Please ask for: Mrs D Johnson
Email: daun.johnson@arun.gov.uk
Telephone: 01903 737762
Our Ref: LU/58/22/A
Your Ref:
Date: 21st March 2022

Town & Country Planning (Control of Advertisement) (England) Regulations 2007 (as amended)

Application for Consent to Display an Advertisement(s)

Development: 1 No internally illuminated fascia sign and 2 No poster signs on front elevation.
Location: 18 Beach Road Littlehampton BN17 5HT

PROPOSED FRONT ELEVATION
Scale: 1/100

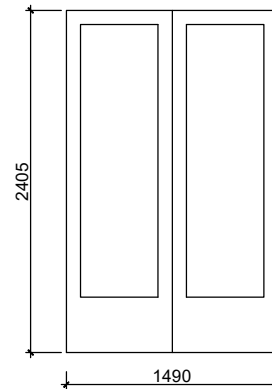
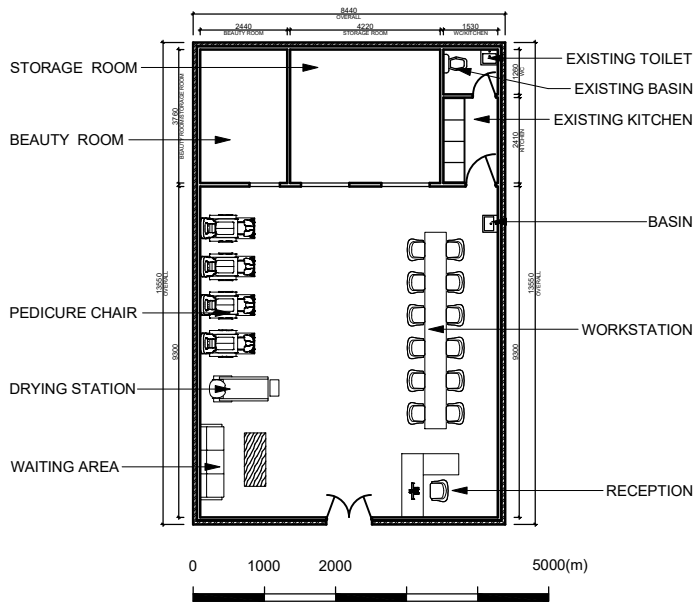
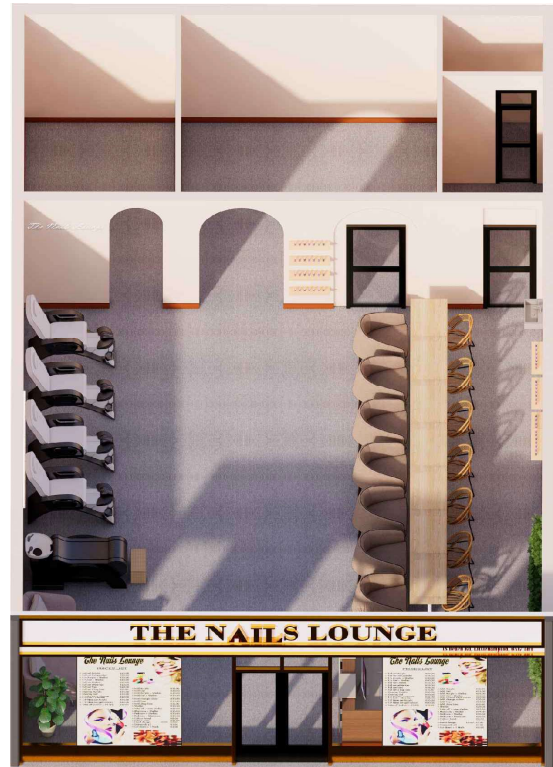
The application form indicates 2 No poster signs on the front elevation. Please show the position of these poster signs on the proposed front elevation.
